RE: Pre-Application Submittal for Widefield Water and Sanitation District Rolling Hills Portable Water Storage Tank, Pursuant to the El Paso County Land Development Code Appendix B, Guidelines and Regulations for Areas and Activities of State Interest ("1041")  
Dated October 2, 2020

December 3, 2020

A preliminary 1041 application for the Widefield Water and Sanitation District Rolling Hills 2MG Potable Water Tanks and Inlet Pipeline was submitted to El Paso County Planning and Development Department on September 2, 2020 per direction by the Department. Comments on the preliminary 1041 application were received on October 2, 2020. The comments requested revisions to the preliminary 1041 application and required a comment response letter stating how each comment was addressed. This letter is intended to serve as the comment response letter. Comments received from the El Paso County Planning and Development Department are included in italics for clarification.

C4

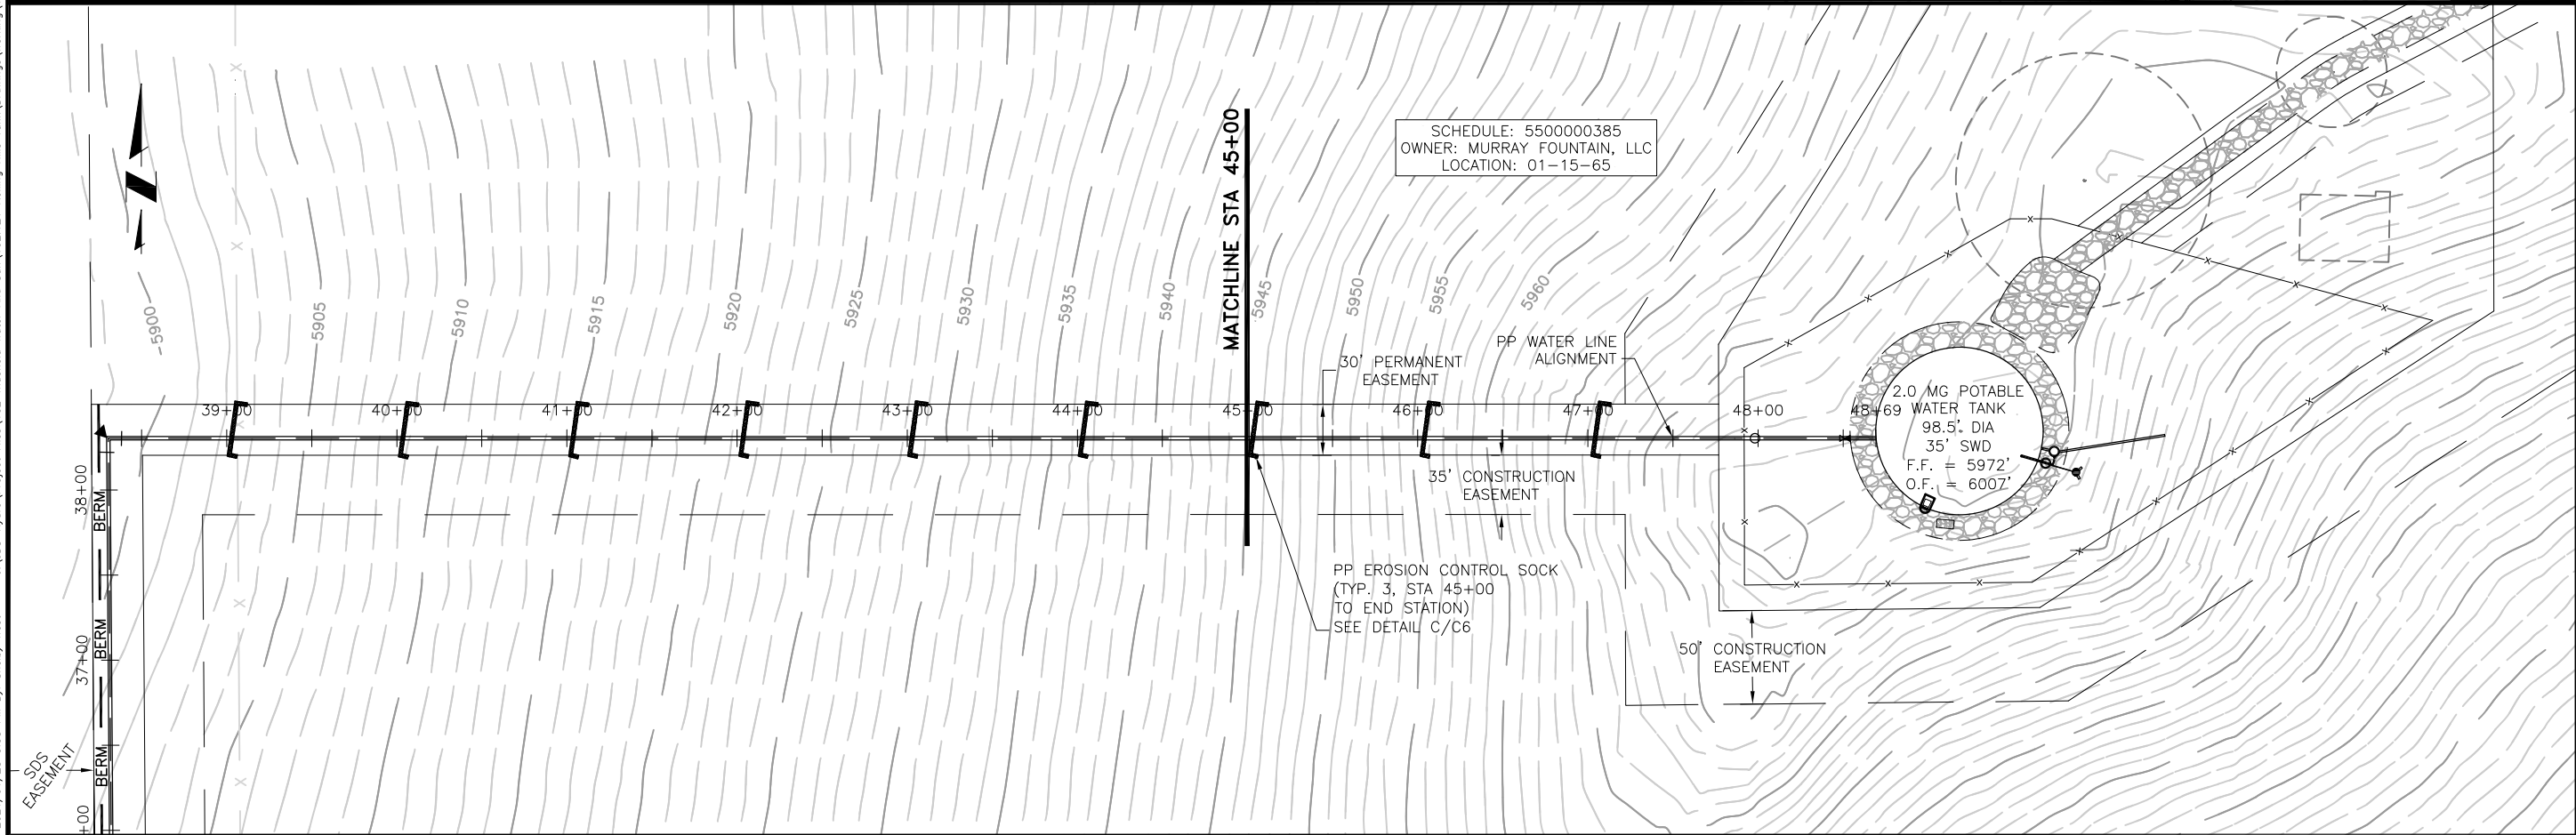
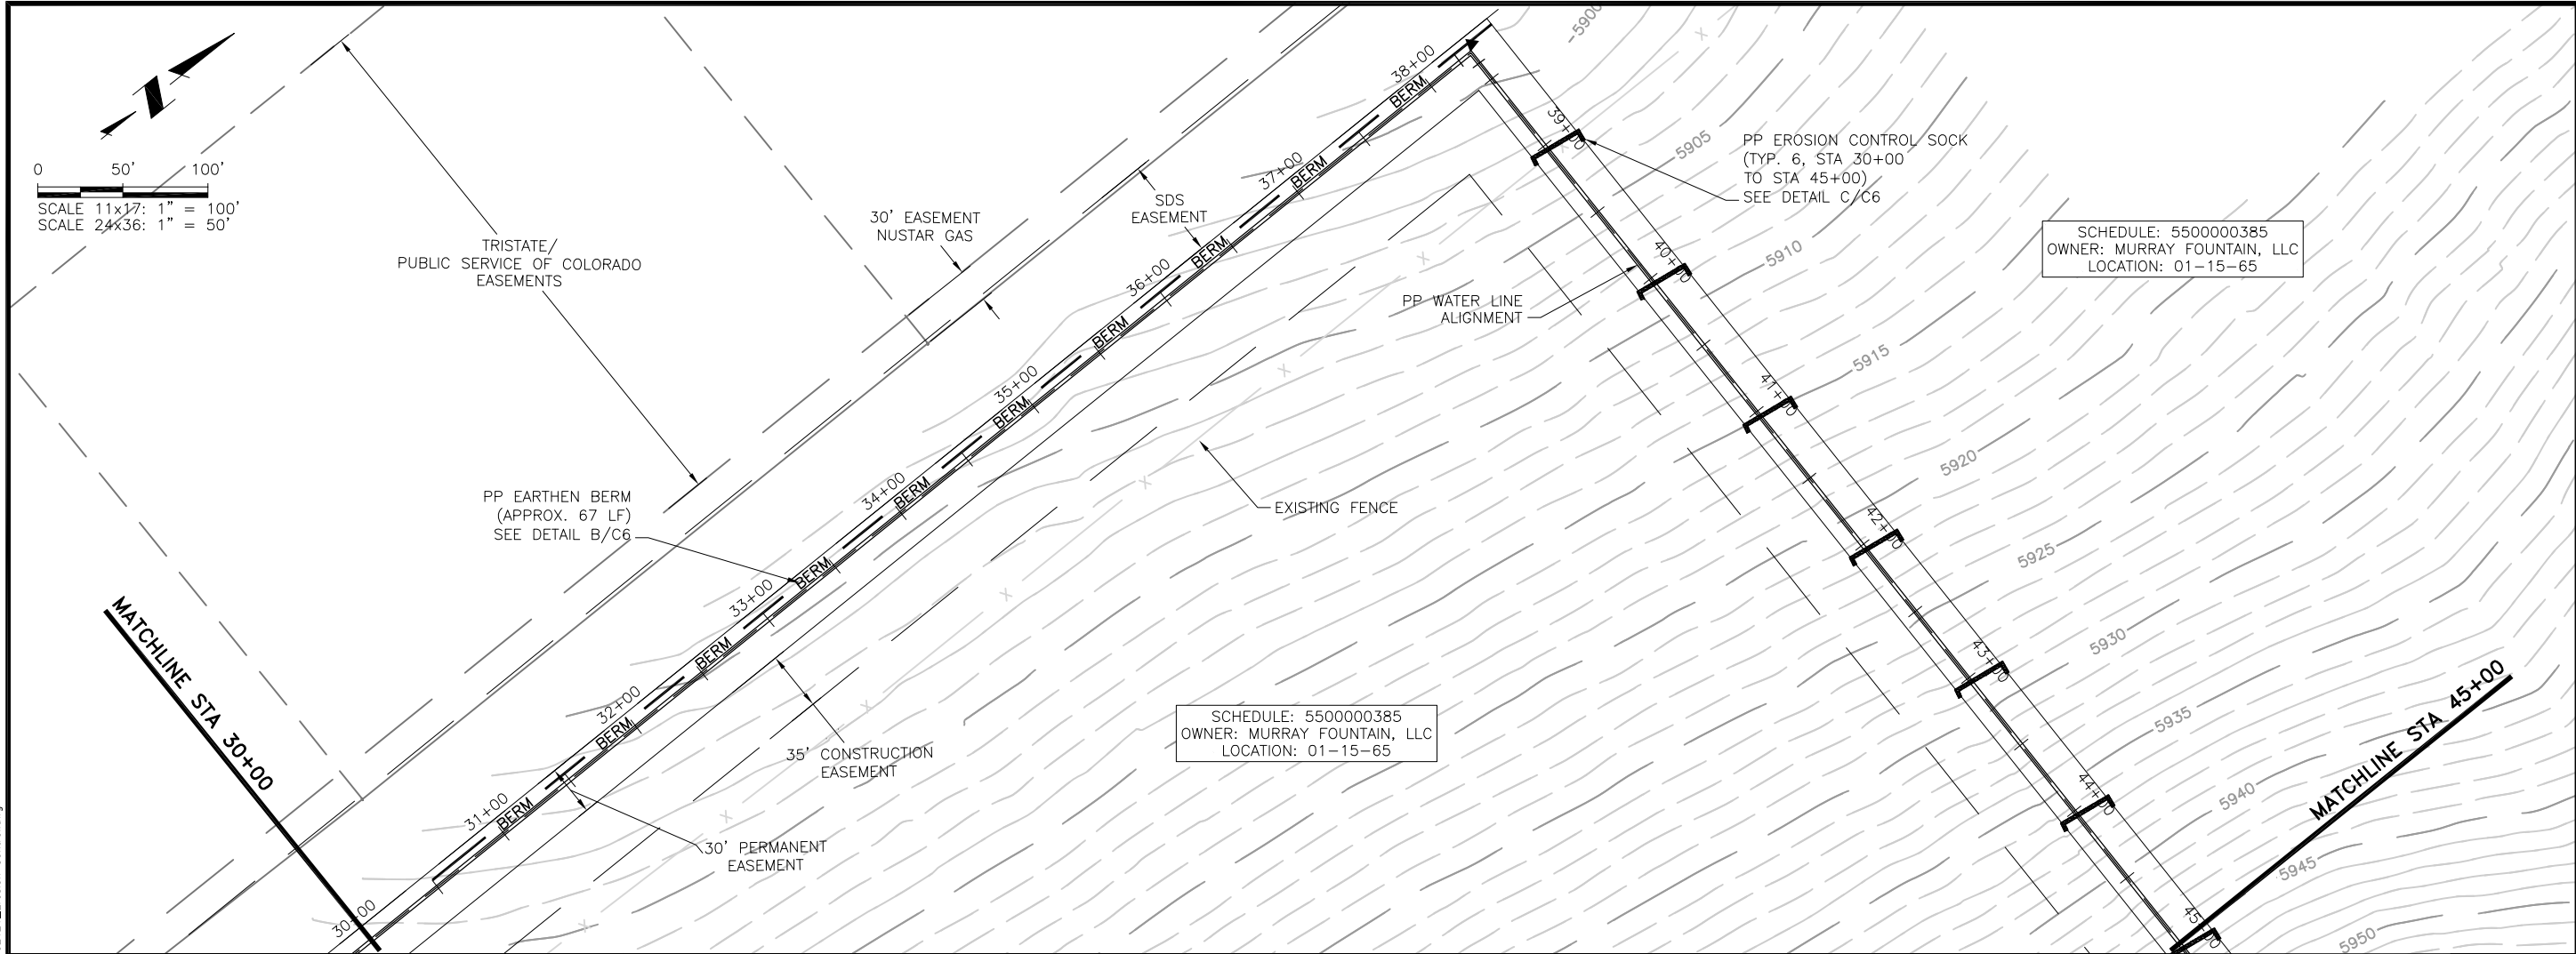
g) *Response acknowledged. Include storm water / drainage conservation techniques in the construction practices please. Preliminary Grading and erosion control plans should be provided for the lines and tanks. The exhibits referenced in the reply.*

The response was updated to reference Appendix B, sheets C2, C4,C5 and C6 included in the preliminary construction plans that include the preliminary grading and erosion control plans.

C VEHICLE TRACKING PAD
C23 SCALE: N.T.S.

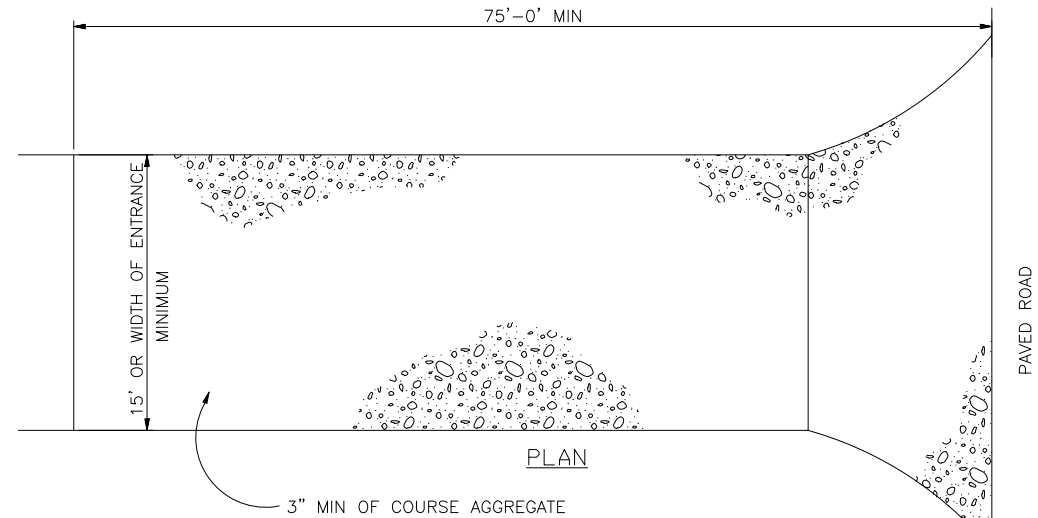
- b) *Provide map please and / or reference an exhibit. A zone map was provided for another project which is incomplete.*

The only public land that will be impacted is an area approximately 18' x 20' that is in the right of way along Drennan Road that is within the City of Colorado Springs. Drawing C23 within the Preliminary Construction Plans included in Appendix B was referenced for a drawing showing the proposed culvert and driveway access.

A
S4 TANK SECTION A
SCALE: 1/16" = 1'-0"

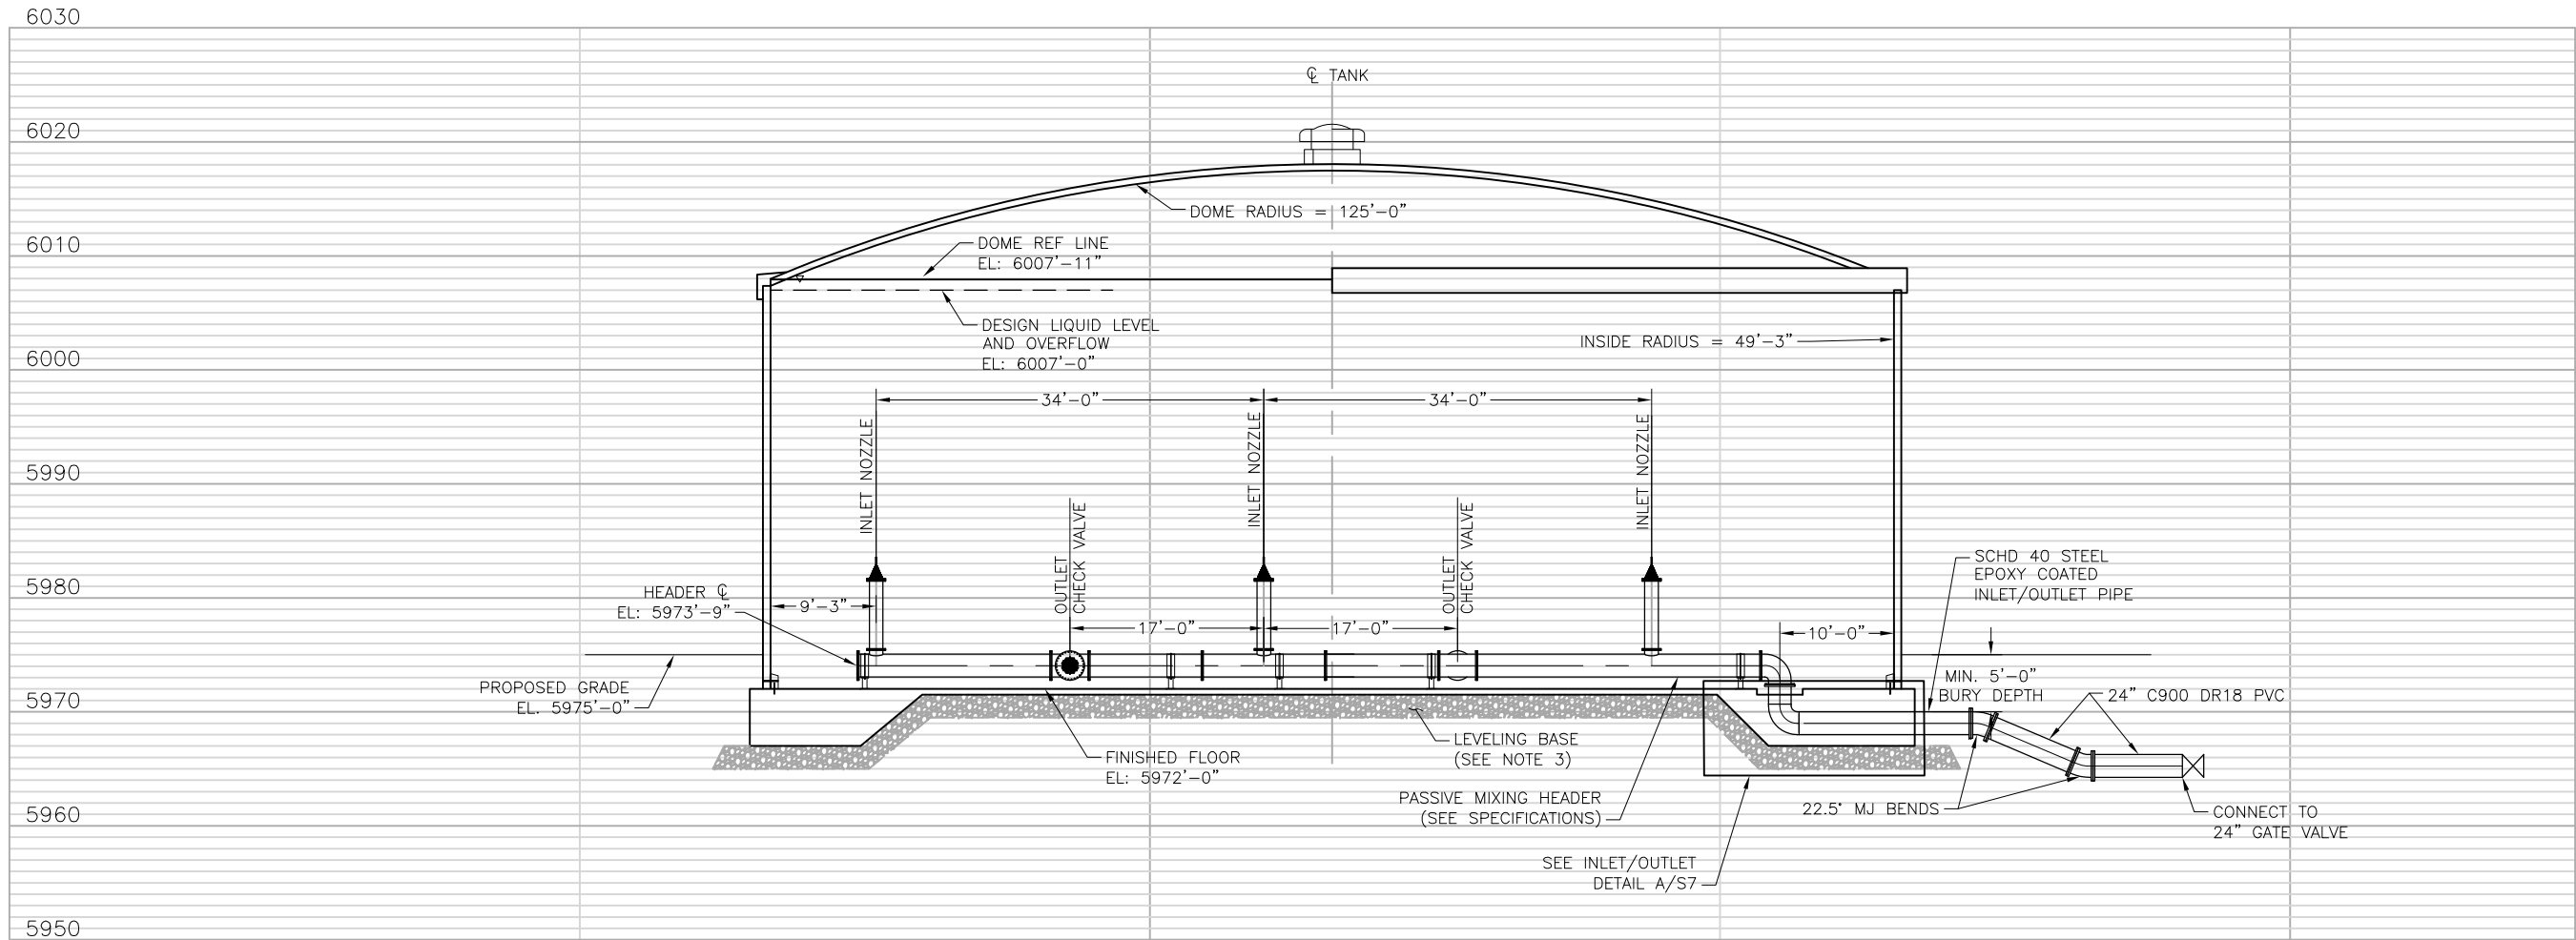
*Address the water tanks. Can the water tanks be fully or partially constructed underground? If not, please provide justification. Provide an exhibit for the elevations of each structure or facility.*

*a) See comments above to item 15 regarding the potential for burying or partially burying the tanks.*

*The response was updated to note the bury depth of 3 feet and why it cannot be buried further. Drawing S4 in the Appendix B was referenced for a tank elevation view.*

*The response was updated to note impacts to the view of the mountains and mitigation including the bury depth of 3 feet. Drawing S4 in the Appendix B was referenced for a tank elevation view.*
